MERIDIAN SERVICE METROPOLITAN DISTRICT
 LATIGO WELL SITE #2
 OVERALL SITE PLAN

MERIDIAN SERVICE METROPOLITAN DISTRICT
 LATIGO WELL SITE #2
 SITE DEVELOPMENT PLAN

**MERIDIAN SERVICE METROPOLITAN DISTRICT**  
**LATIGO WELL SITE #2**  
**OVERALL SITE PLAN**

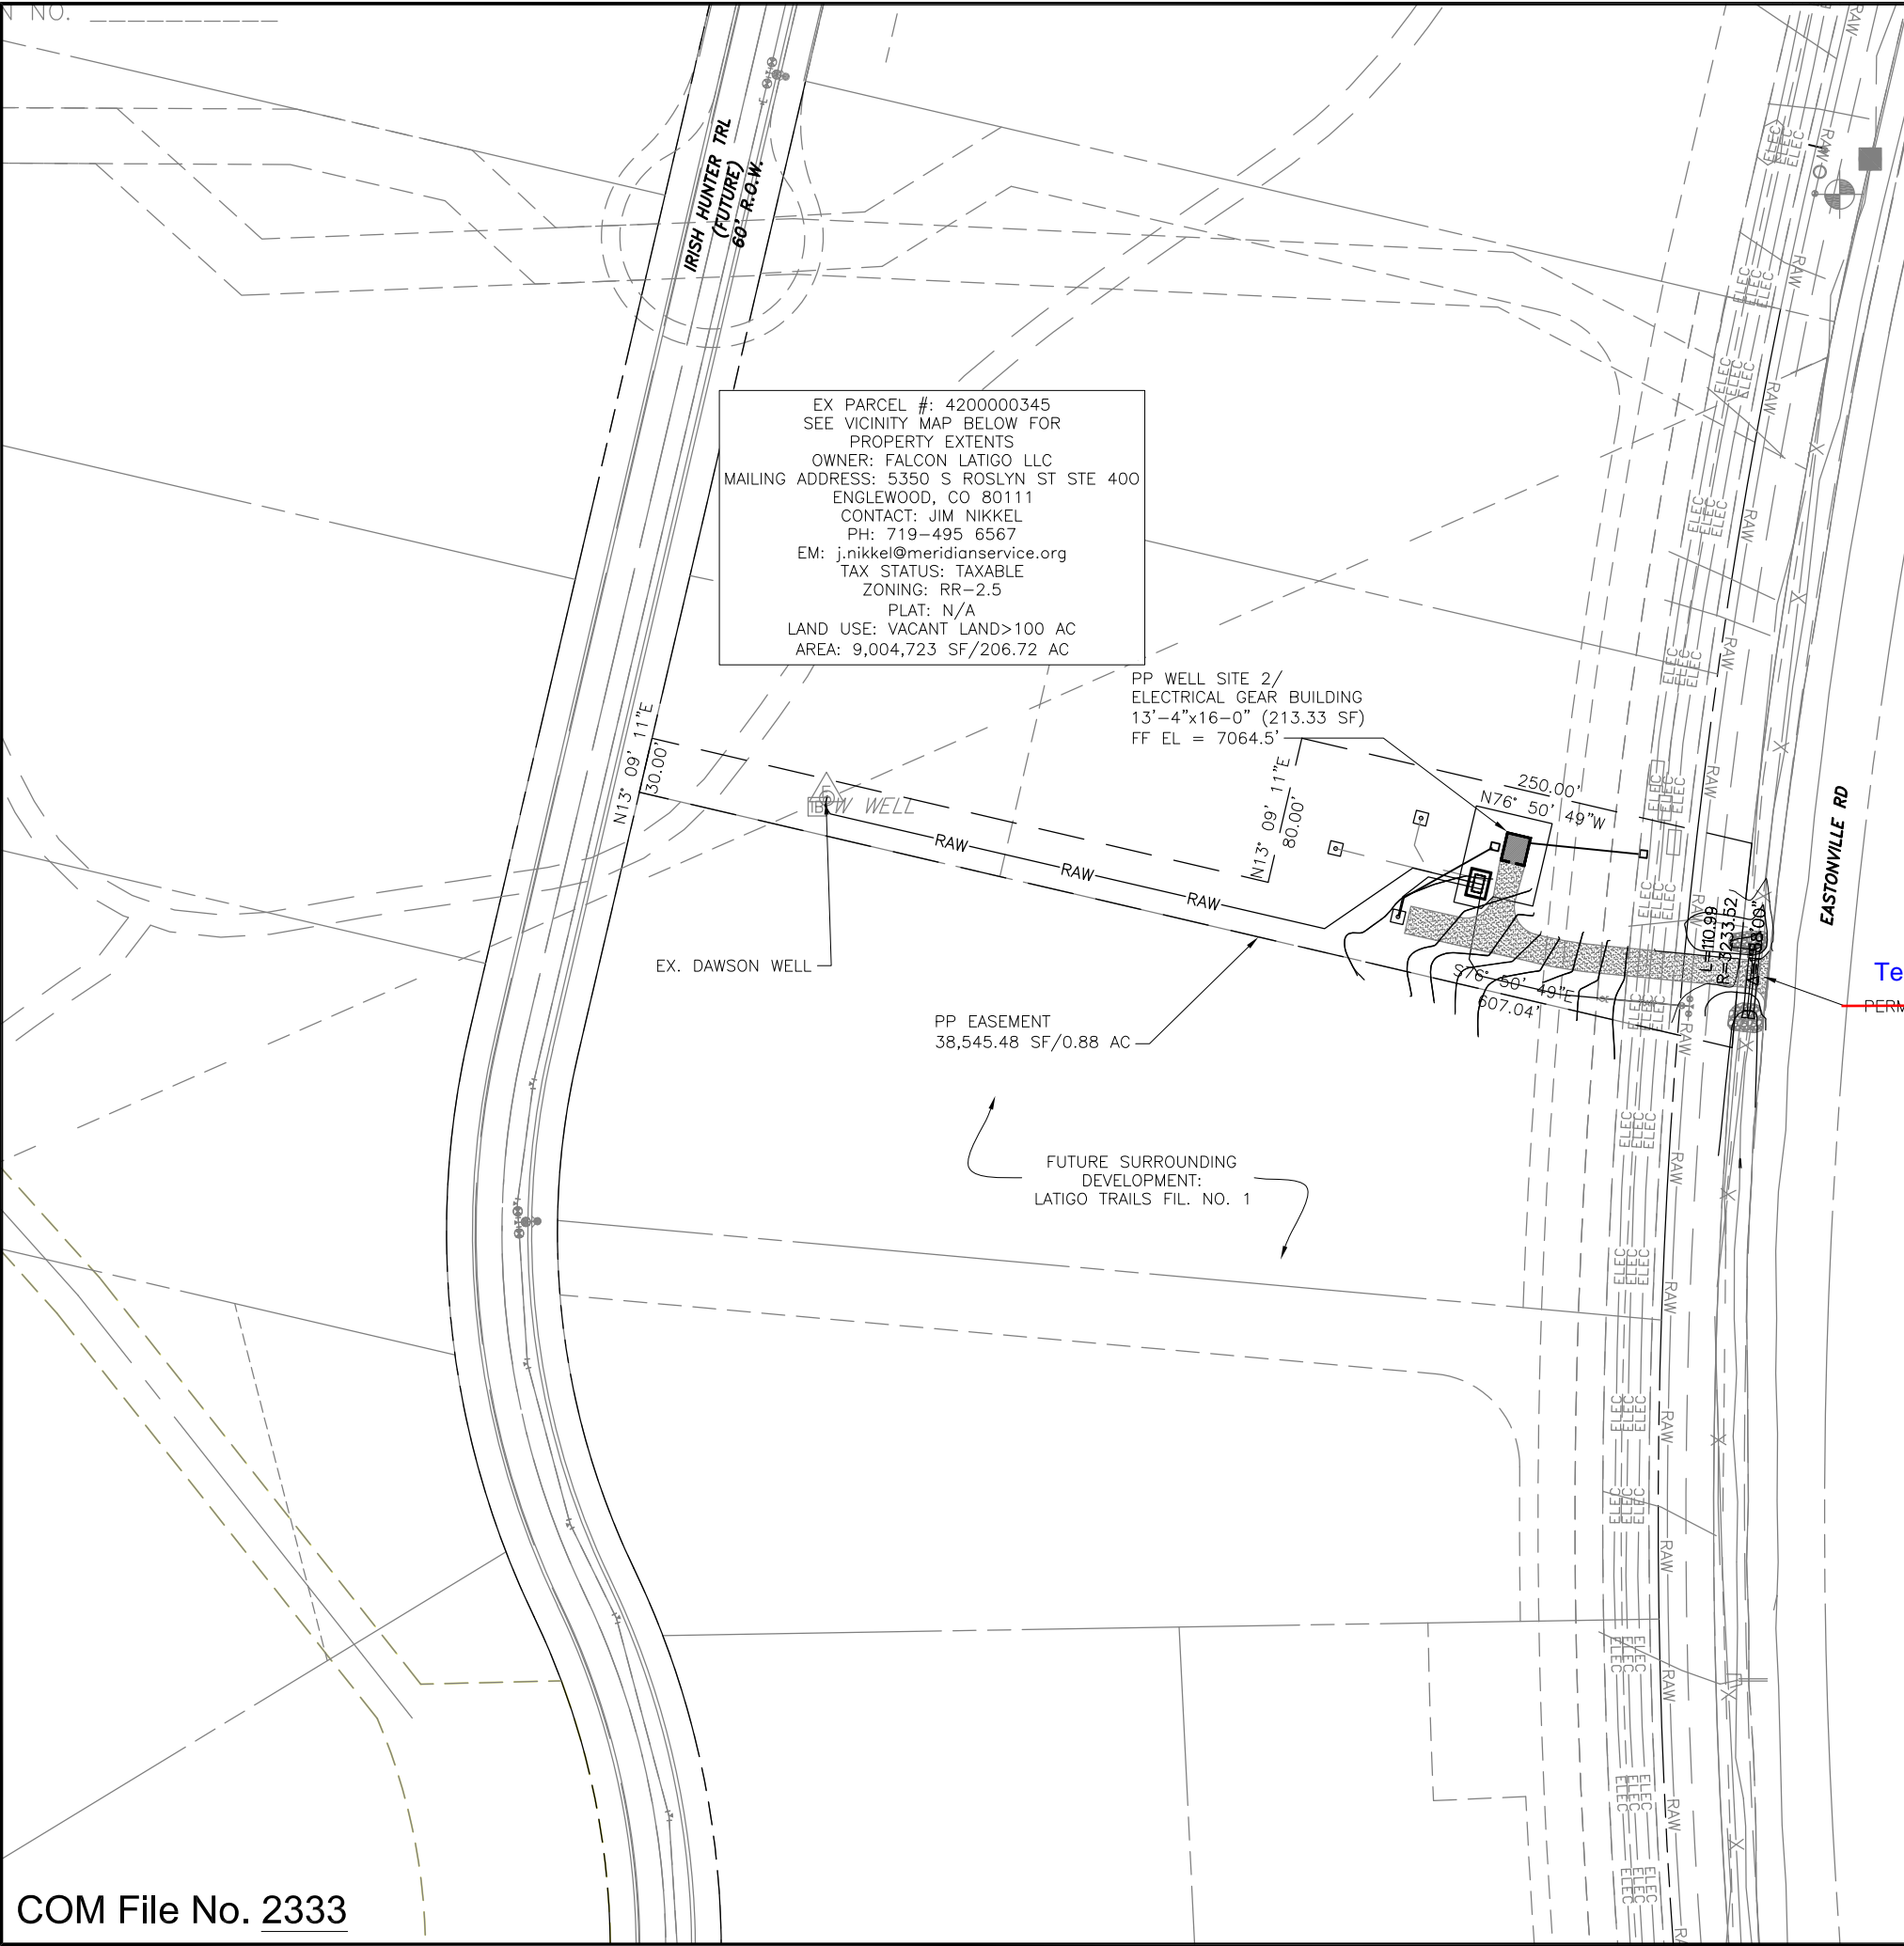
Label as future permanent access drive

V1 comment: Show and label the future/permanent driveway access to the future road, and the associated access easement.

Add a note stating the Meridian Service Metropolitan District shall remove the temporary access and construct the future driveway within 6 months of the local roadway being preliminarily accepted by the County.

This will be a temp drive access per V1 comment.

Remove lot lines or label as future in legend per V1 comment

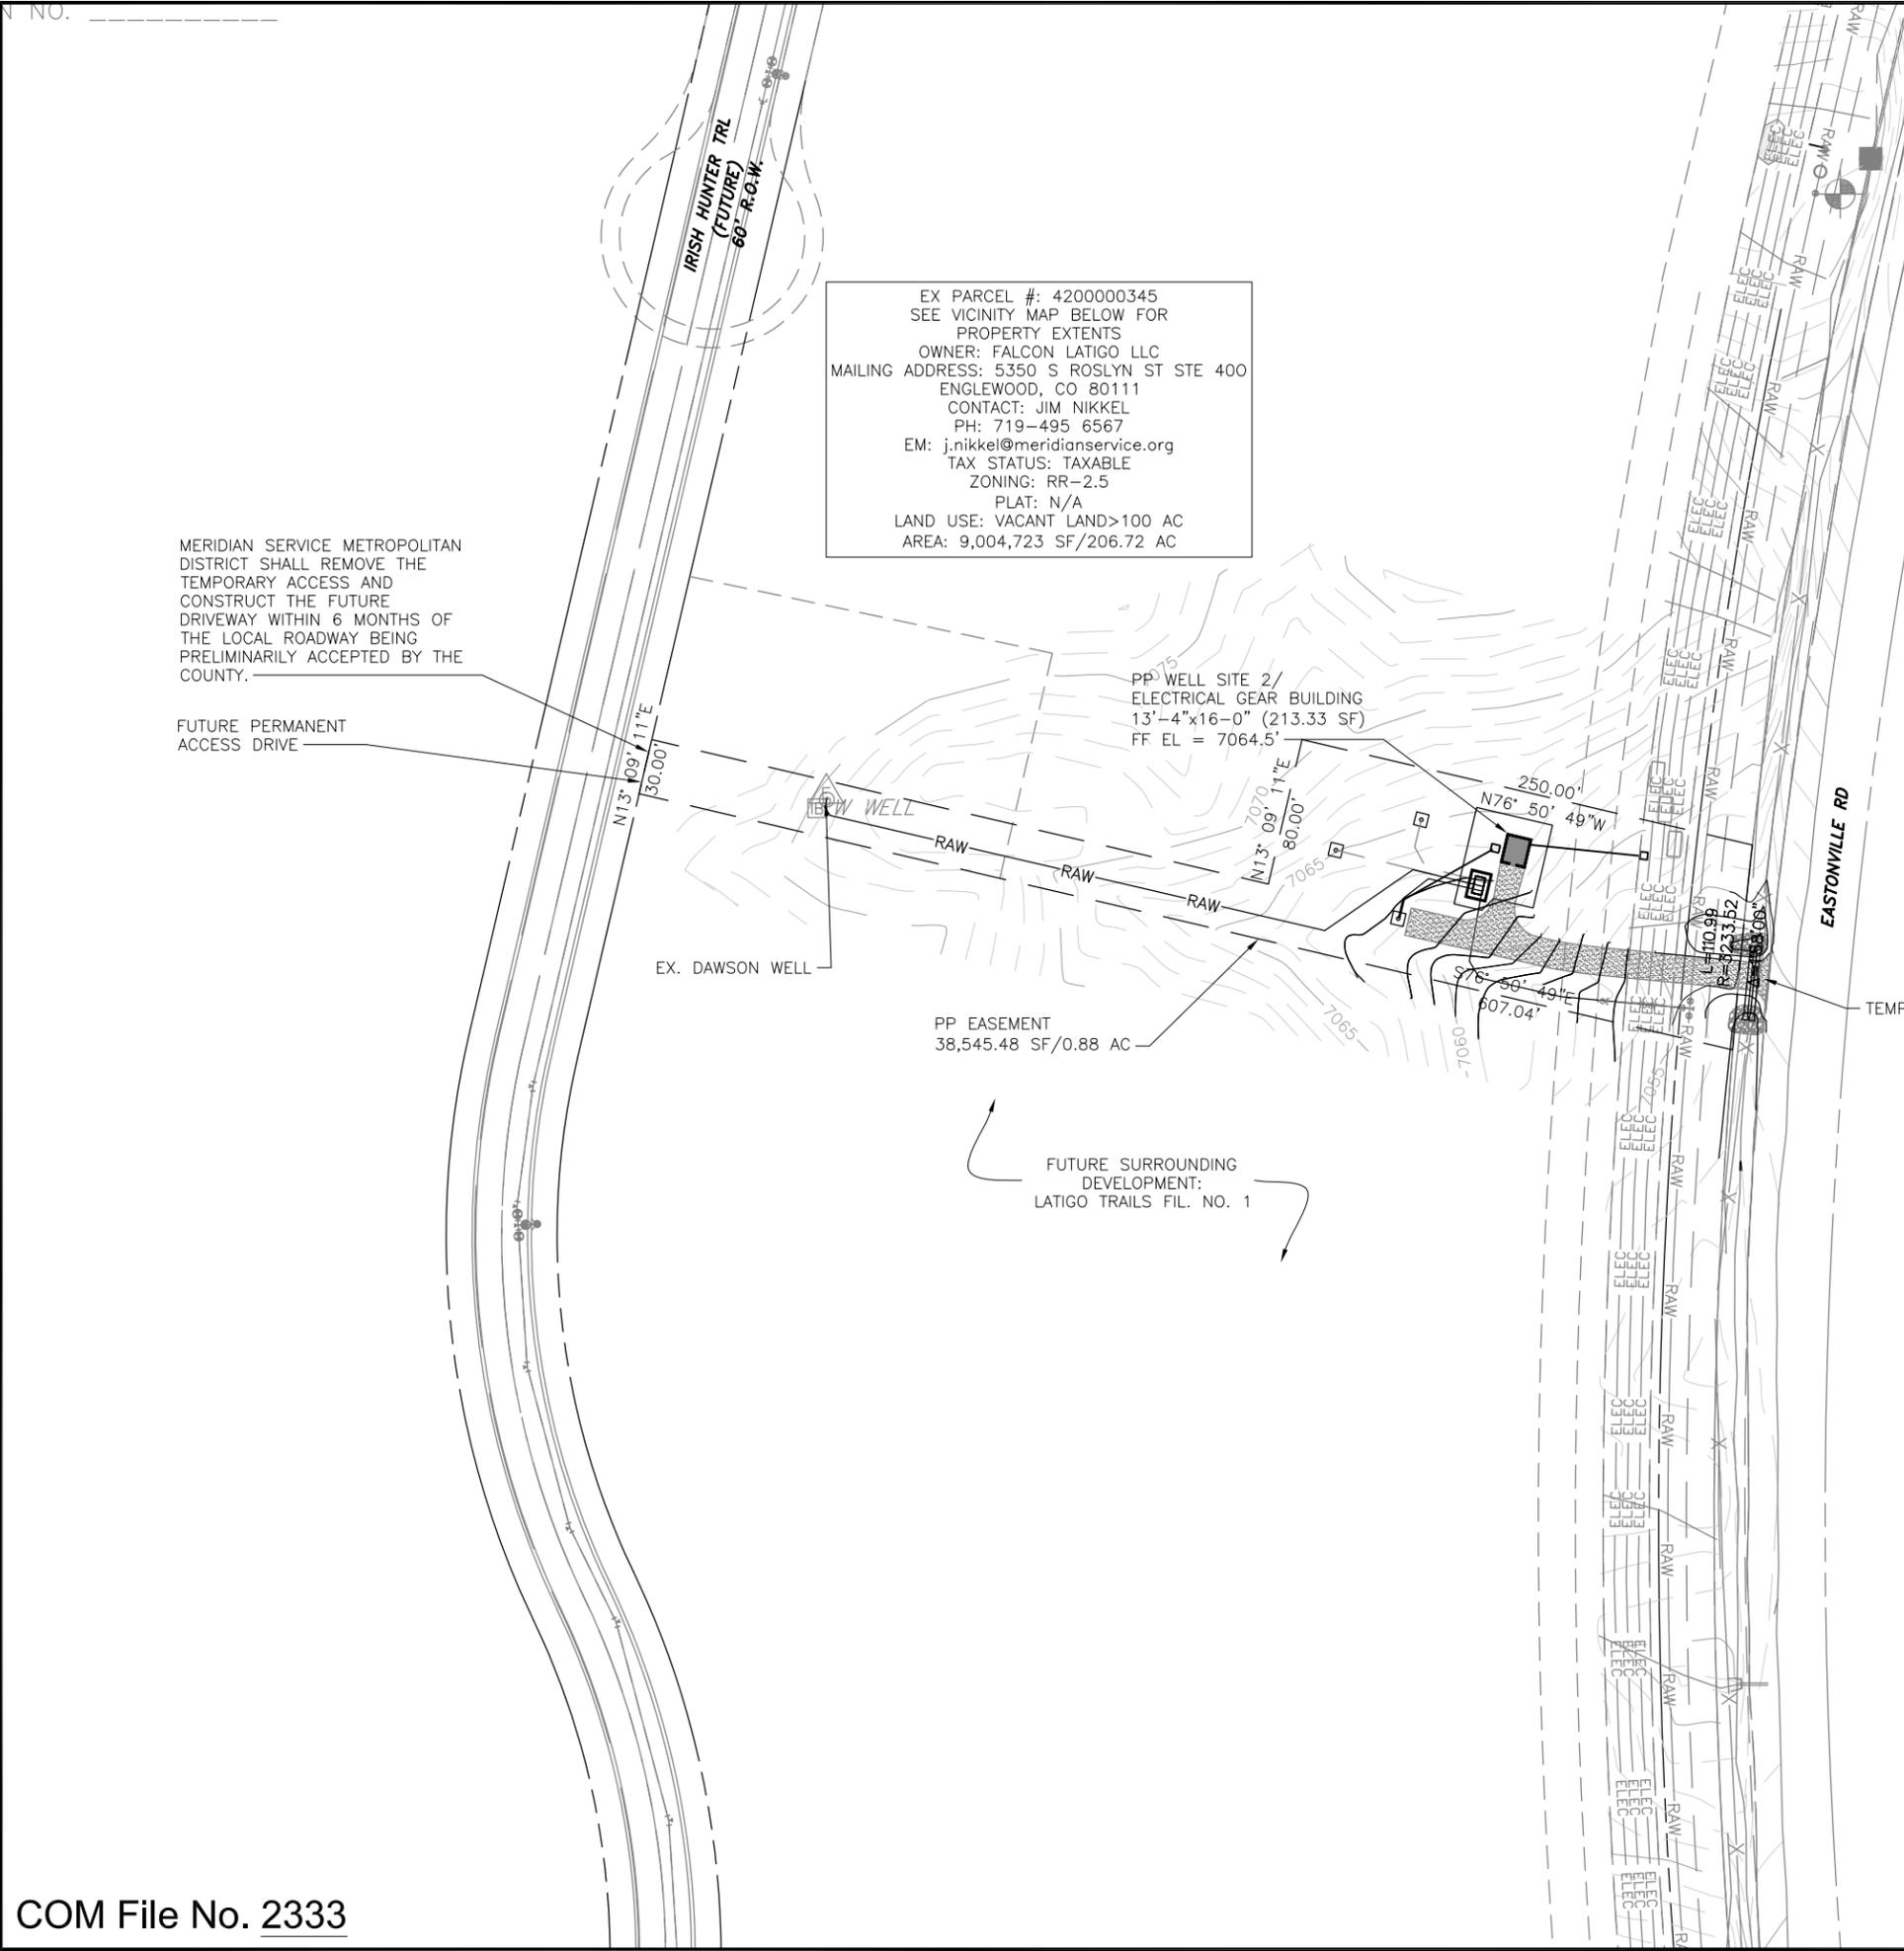
V1 comment: Submit a drainage letter with analysis of the road side ditch flows and culvert sizing to verify the appropriate culvert sizing is shown
